CITY OF PORTLAND, MAINE

January 28th, 2013

Project Name: **Mixed Use Development at 321 Commercial Street (corner Maple Street)**
Project ID: 2012-615 CBL: 40-E-3
Address: 321 Commercial Street
Applicant: J B Brown & Sons
Planner: Jean Fraser

SITE PLAN

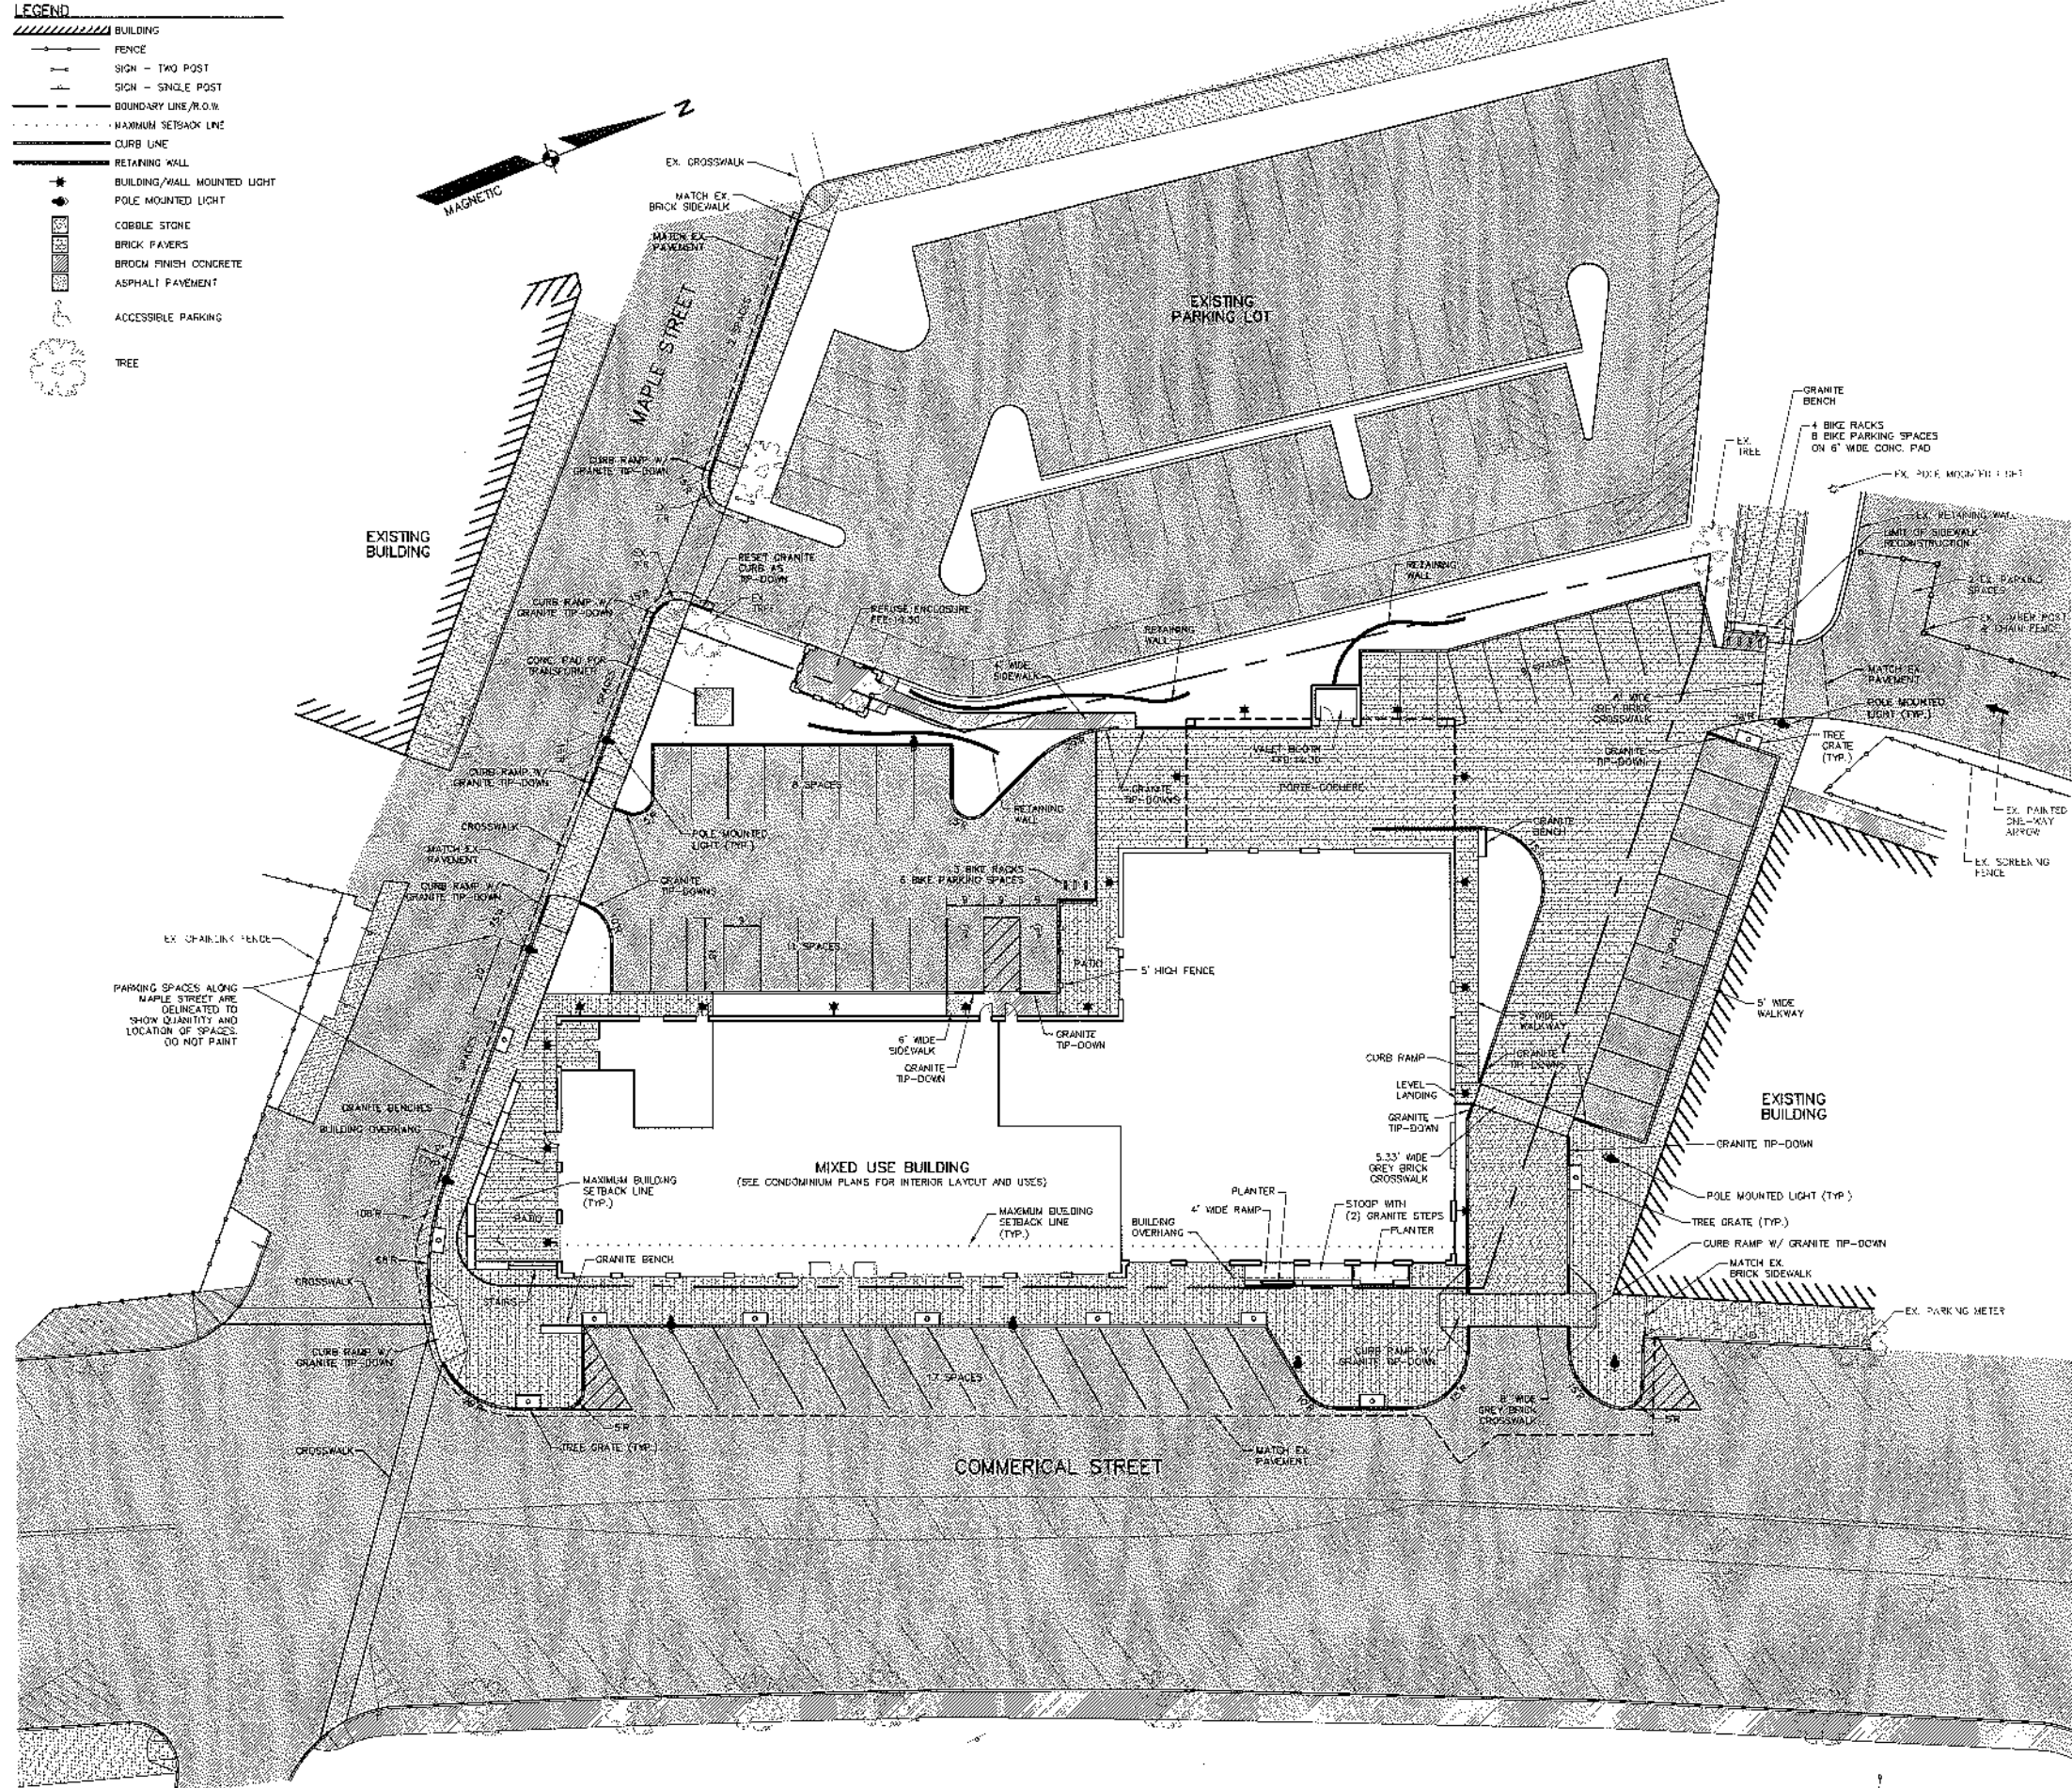
The Planning Board waives Technical Standard, Section 1.20.1, to allow a reduction in the required sight distance to the centerline of the crosswalk on the east side of Commercial Street, subject to the removal of an additional parking space nearest to the crosswalk, as based on Plan CO4 Rev 1.15.2013.

* November 9, 2012 Comment: The painted areas at the driveway entry on Maple Street should be removed.

* November 9, 2012 Comment: The applicant has illustrated a proposed crosswalk on Commercial Street at the easterly corner of Maple Street. I need to review this proposal. My general sense is additional features are needed for safe pedestrian crossing. I would also note that the alignment of the crosswalk on the site plan will need to be adjusted to meet the City's perpendicular alignment design preference. The crosswalk paint detail would also need to be "Block" style.

- o **The Commercial Street crosswalk shall not intersect the Maple Street crosswalk at an "apex" location. Separate crosswalk ramps shall be constructed on the project site corner. This change may require some adjustment to the proposed stormwater planter.**

- o **For improved safety it is suggested that an additional parking space be eliminated on Commercial Street abutting the proposed crosswalk. Accordingly, the striped island will need to be expanded.**
- o **The applicant shall install crosswalk warning signs that meet standards in the MUTCD.**

* November 9, 2012 Comment: The 11 parking spaces on the former Foundry Lane do not appear to meet City dimensional standards. A waiver will be required. I would also note that there is general concern about pedestrian accessibility in this area and modifications to the plan may be necessary.

* November 9, 2012 Comment: I need to review the design details on the diagonal parking on Commercial Street (e.g. dimensions, painted corner areas, etc.).

December 12, 2012 Comment: The dimension of the diagonal parking spaces are not consistent with existing diagonal parking spaces located on Commercial Street. The spaces seem to be longer. I'll need to coordinate with DPS staff.

December 12, 2012 Comment: The plans have been revised to note that areas are not to be painted. I have no further comment.

Status: I support the proposed crosswalk on Commercial Street with the following suggested changes. I would further note that this crosswalk was reviewed by the City's Crosswalk Committee and the Committee provided conditional support. Final approval of the details by the Committee will be required:

Status: It is suggested (not recommended) that the parking space dimensions match those of other parking spaces on Commercial Street. I'm comfortable if the parking space dimensions remain unchanged if the alignment of the westbound travel lane on Commercial Street is not off-set or requires vehicles to shift.

STORMWATER PLANTER PLAN
NOT TO SCALE

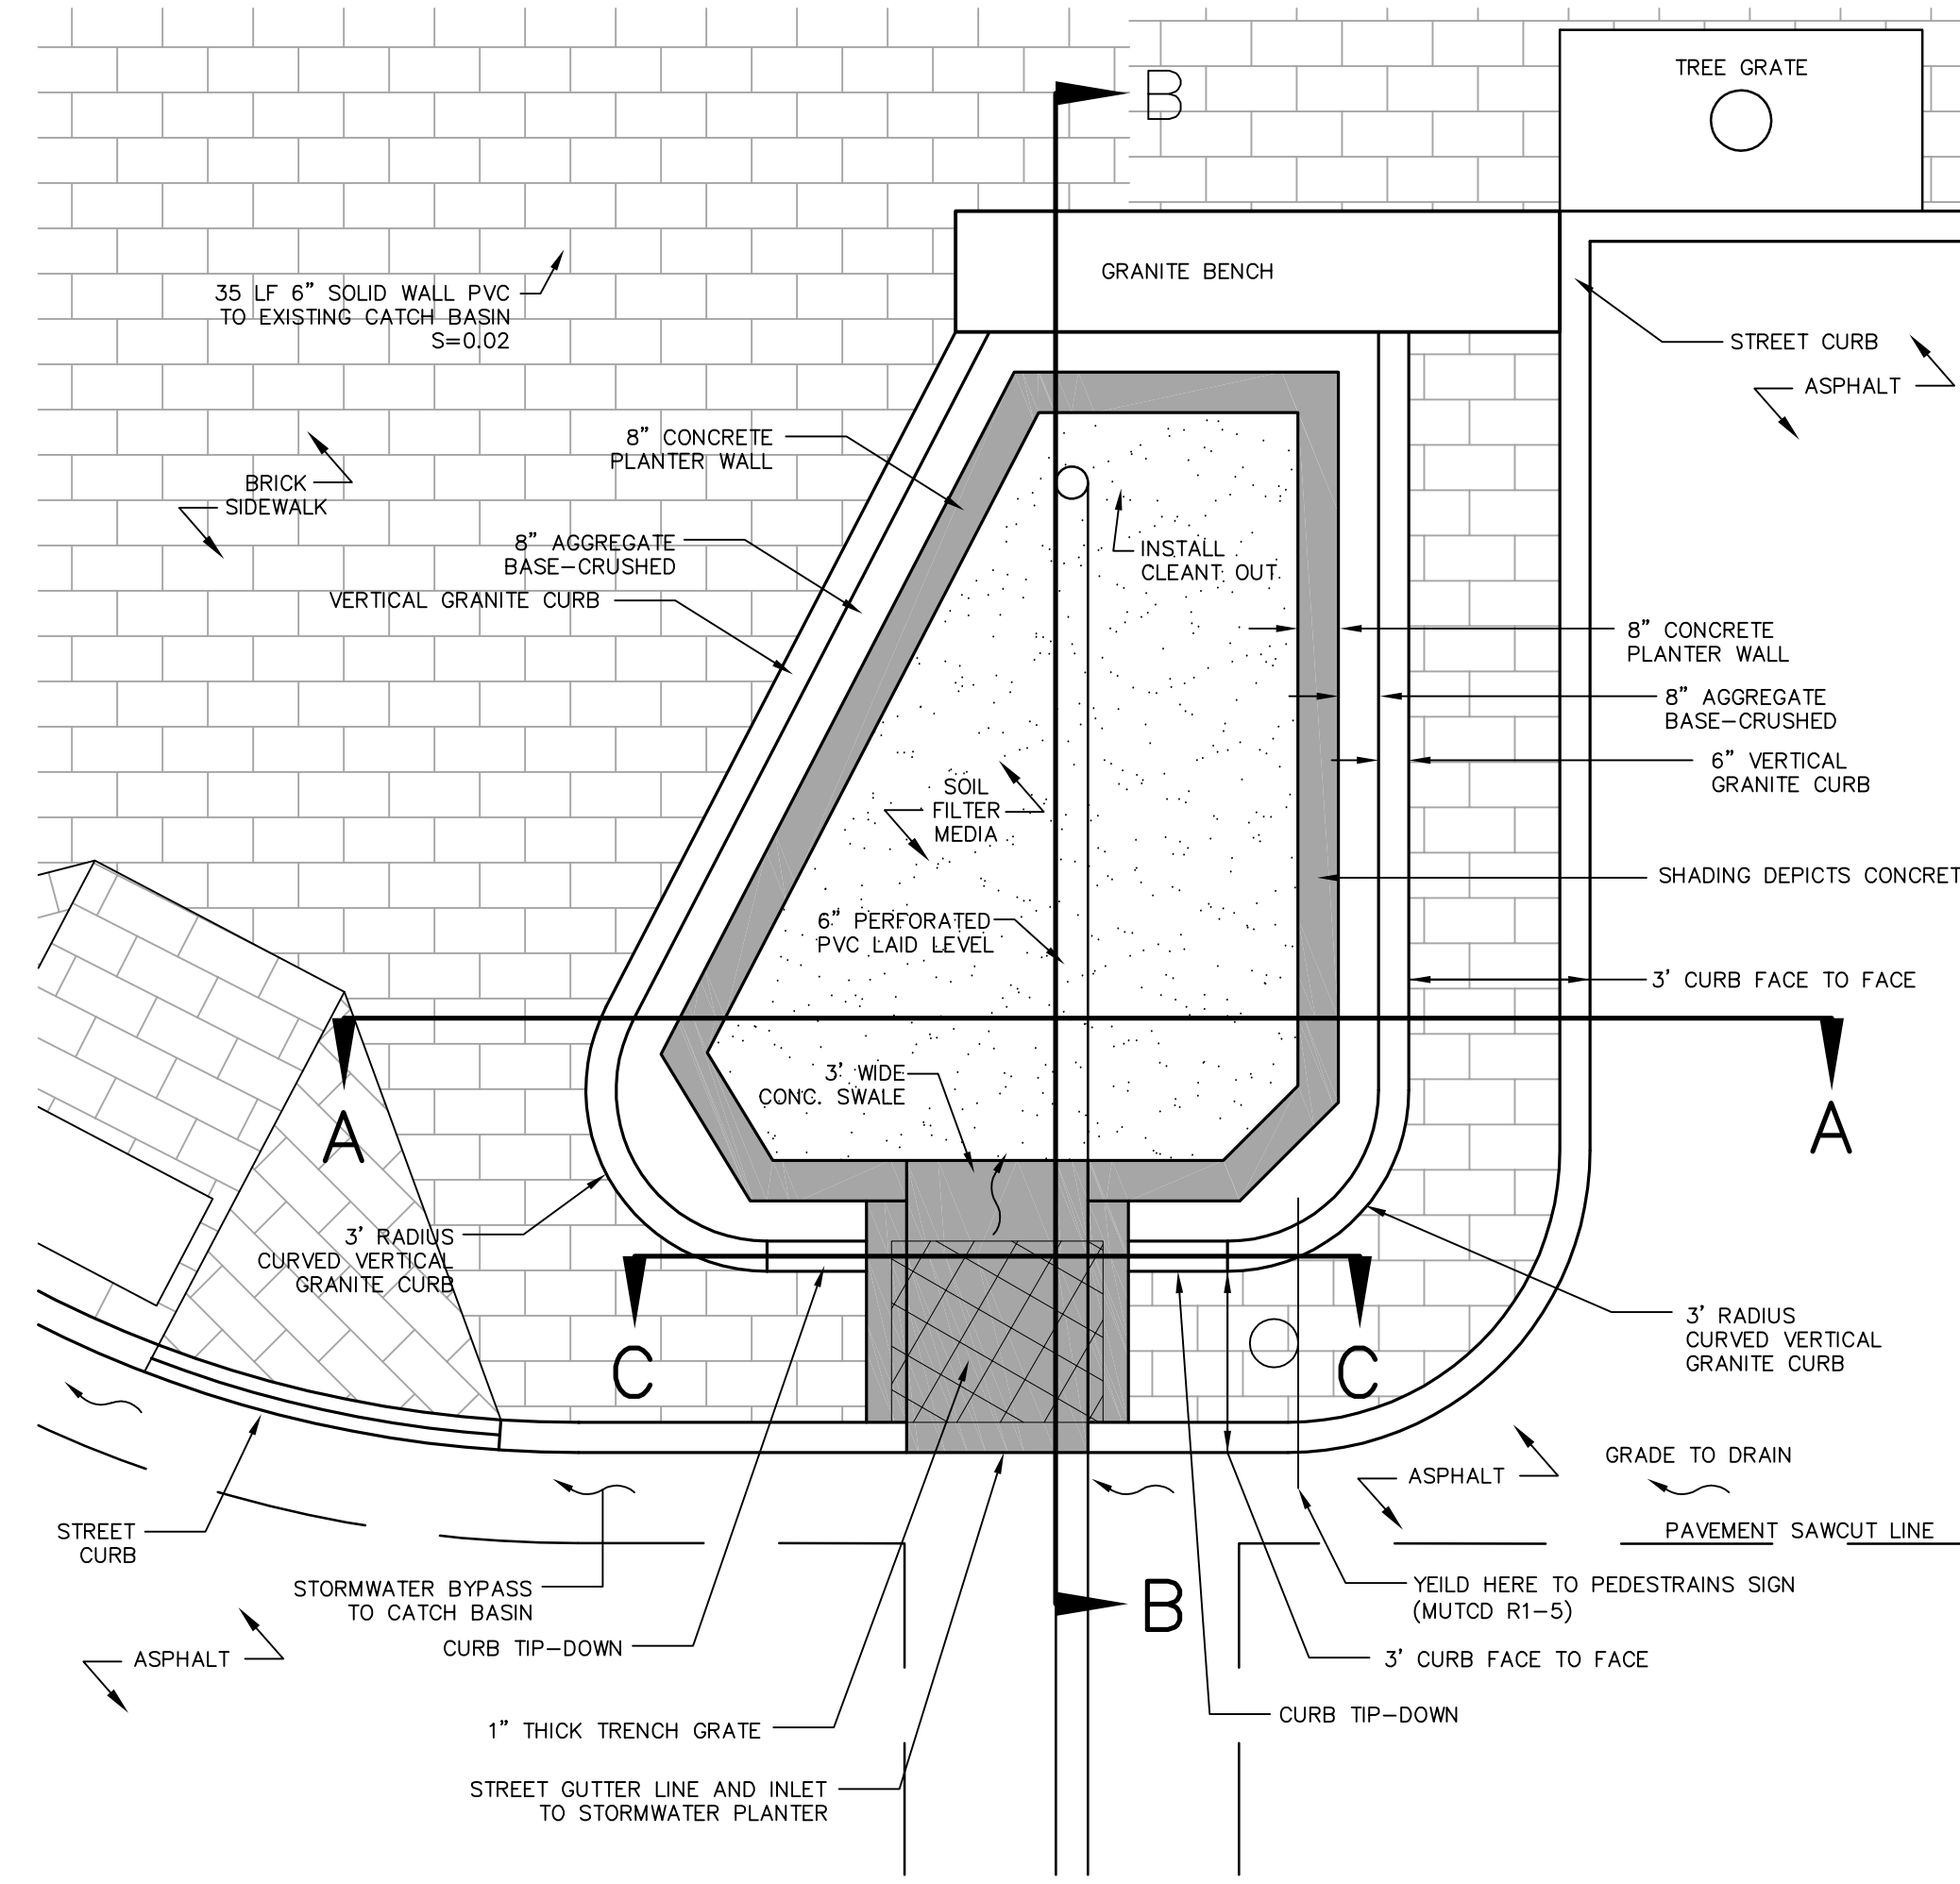
8. That the Stormwater Planter underdrains shall not be tied into the existing catch basin in Maple Street, but shall be directly connected to the City's 18inch RCP stormdrain in Commercial Street via an insert-tee connection; and
